DEVELOPMENT REVIEW BOARD
SUPPLEMENTAL SUBMITTAL

PROJECT NO. PR-2019-00204
Application No. SD-2022-00020

Re: Preliminary Plat Review for Proposed Subdivision of Tracts 12-B-1-A and 12-B-1-B of El Rancho Grande I

Preliminary Plat for Sombra Del Oeste Being Comprised of Tracts 12-B-1-A and 12-B-1-B El Rancho Grande I City of Albuquerque Bernalillo County, New Mexico February 2022

### This Sheet Shows Existing Information for Entire Subdivision (Including Vacated Easements, Existing Underground and Above Ground Utility Lines)

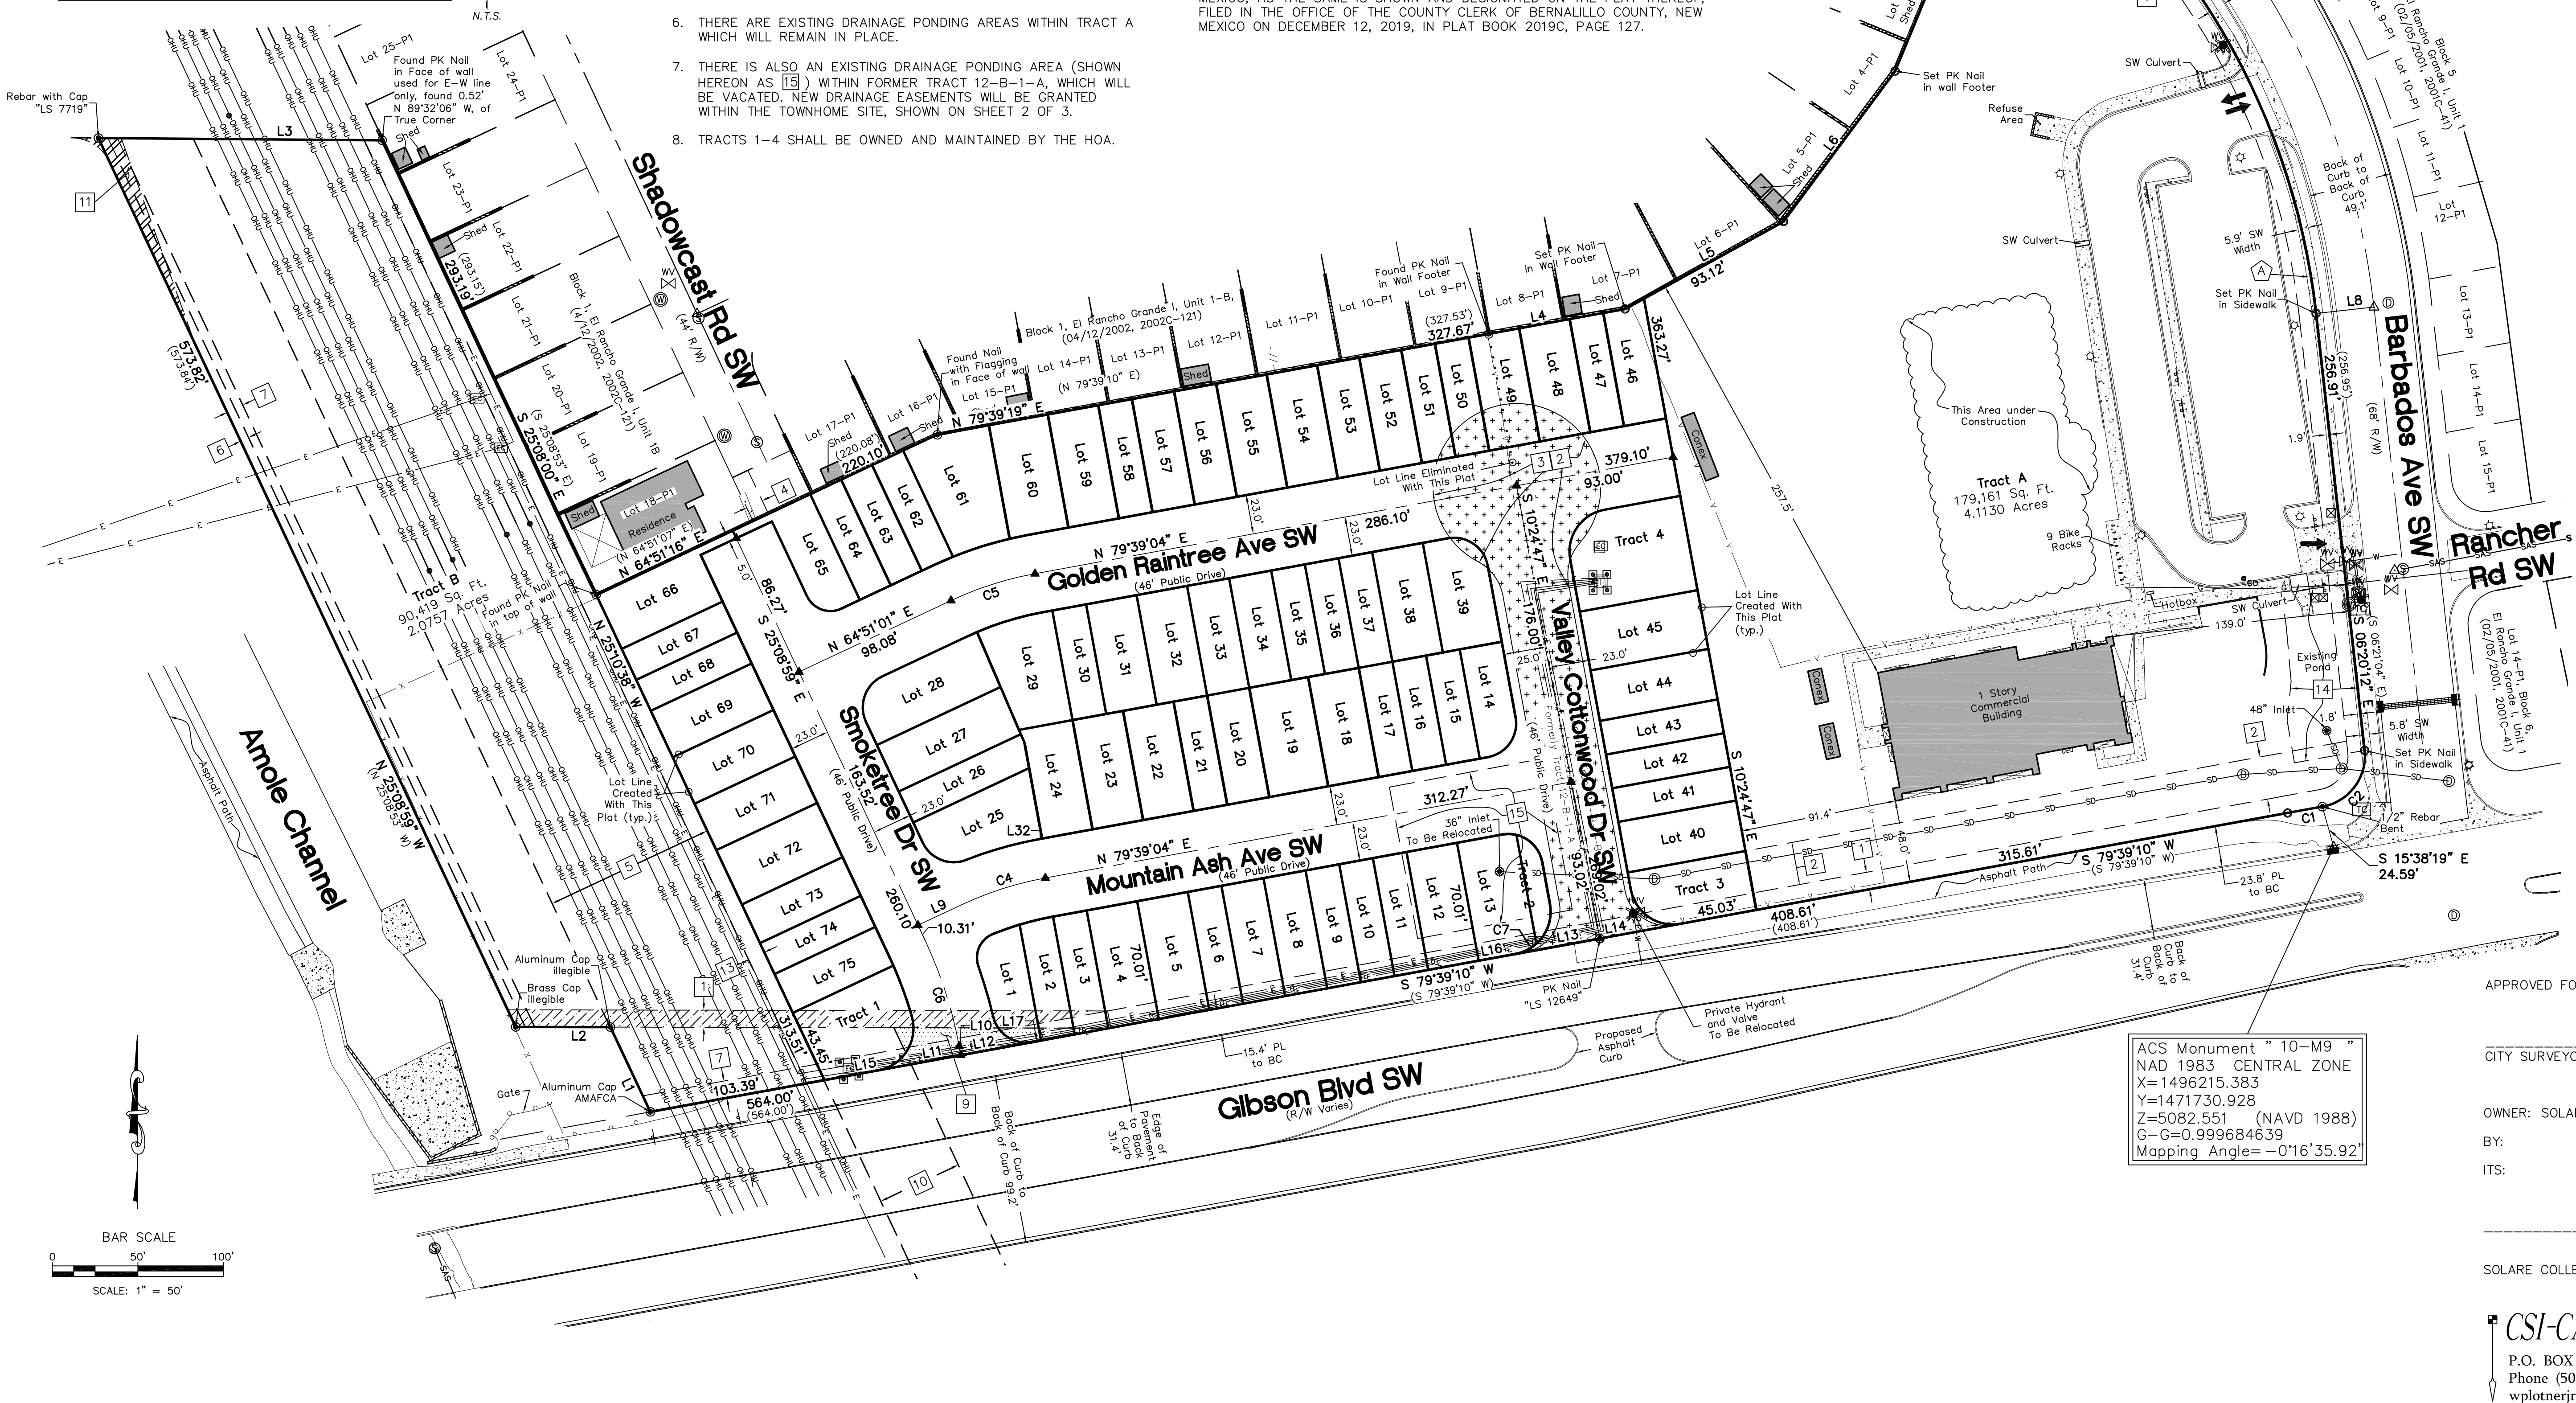
1. Easement #9 (existing 20' permanent waterline easement) is shown to be located within Smoketree Dr. in the proposed right-of-way. Shouldn't this be vacated with this plating action, assuming 811 line spots have been confirmed not to have any infrastructure?
2. Easement #10 (existing permanent access road and waterline easement) extends into proposed Tract 1. Shouldn't this be vacated with this plating action, assuming 811 line spots have been confirmed not to have any infrastructure?

Easement 9 and portion of easement 10 are now vacated as shown on preliminary plat. 811 spotting showed these areas to not be occupied.

**SECTION A-A**  
GOLDEN RAIN TREE AVENUE SW, MOUNTAINASH AVENUE SW, SMOKETEE DRIVE SW

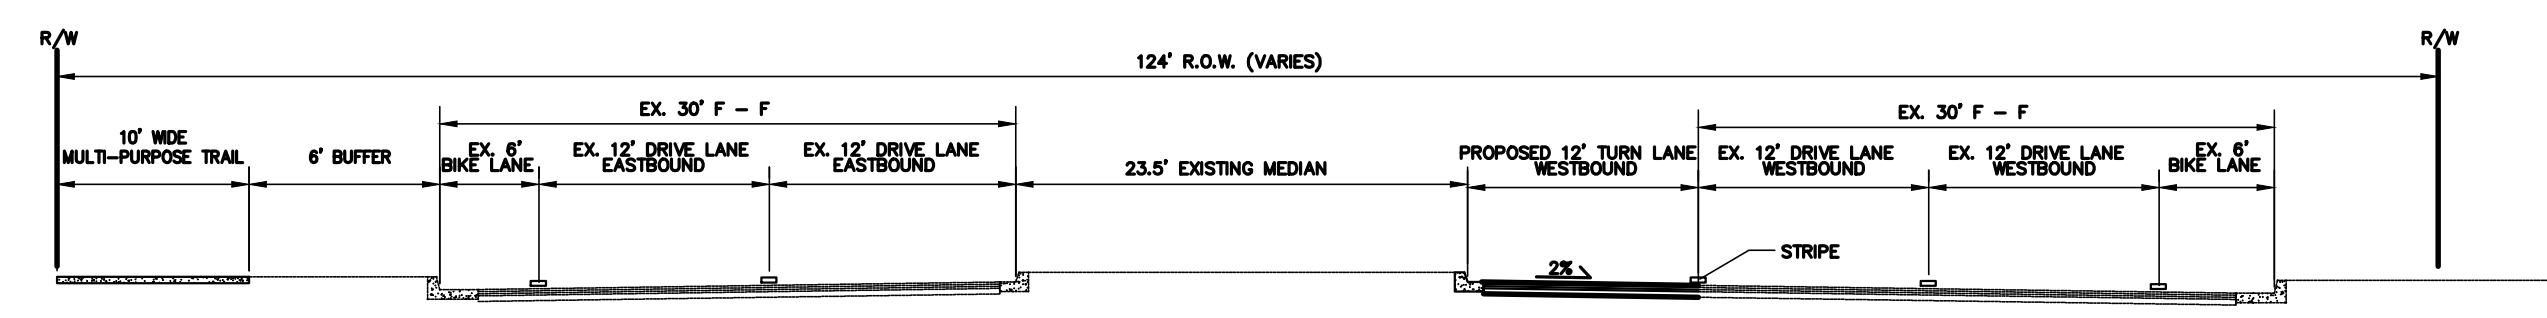
2. The infrastructure list should indicate 5-foot sidewalk for all roads per the cross-section details. For further specification, include a note to refer to deferred sidewalk per the Sidewalk Exhibit.

Noted, infrastructure list has been modified to include sidewalk or is covered under deferral of sidewalk request.
